CITY OF ALBUQUERQUE

January 13, 2014

**Re: 7503 Oakland Ave., Jasmine Subdivision
Grading and Drainage Plan
Engineer's Stamp Date 12-23-13 (C19D060)**

7503 OAKLAND
BEING A REPLAT OF LOT 20, BLOCK 3, UNIT 2, TRACT 3, NAA
GRADING & DRAINAGE PLAN

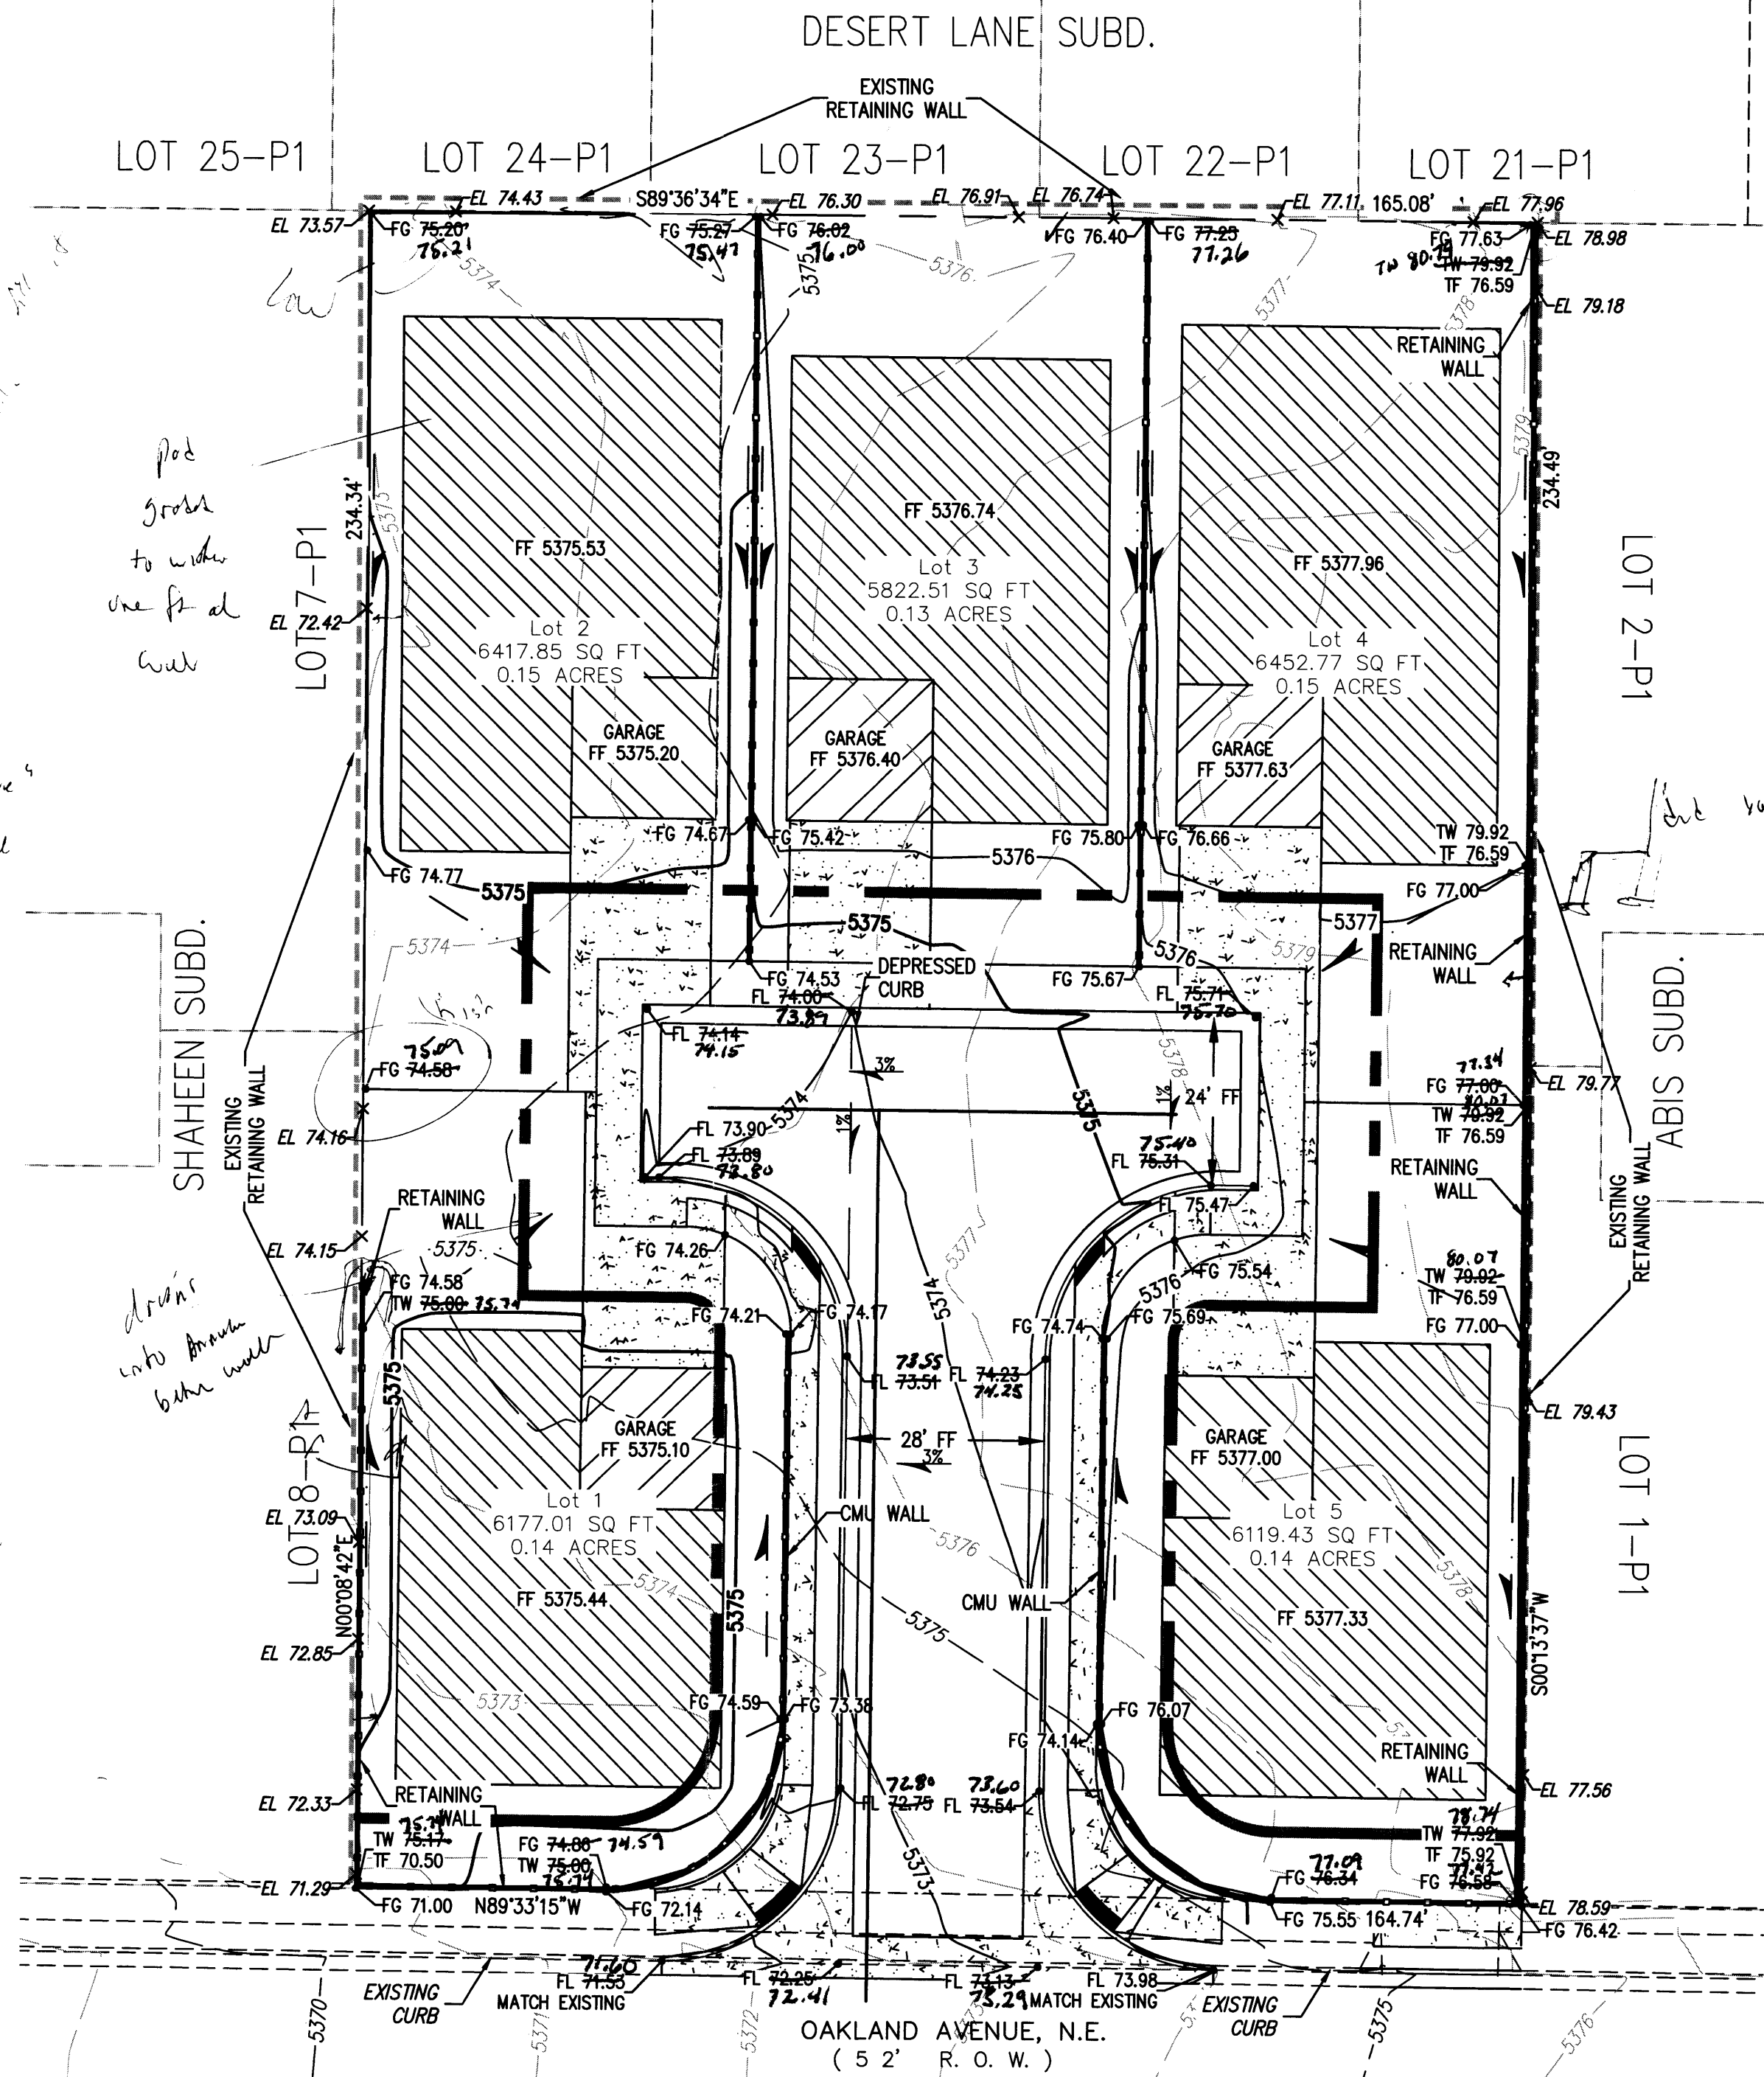
1. Include a statement that the existing retaining wall(s) are acceptable for the additional fill proposed on the engineer's certification or if the wall(s) are found to be unacceptable a revised plan will have to be submitted in order for Hydrology to approve the retaining wall permit.
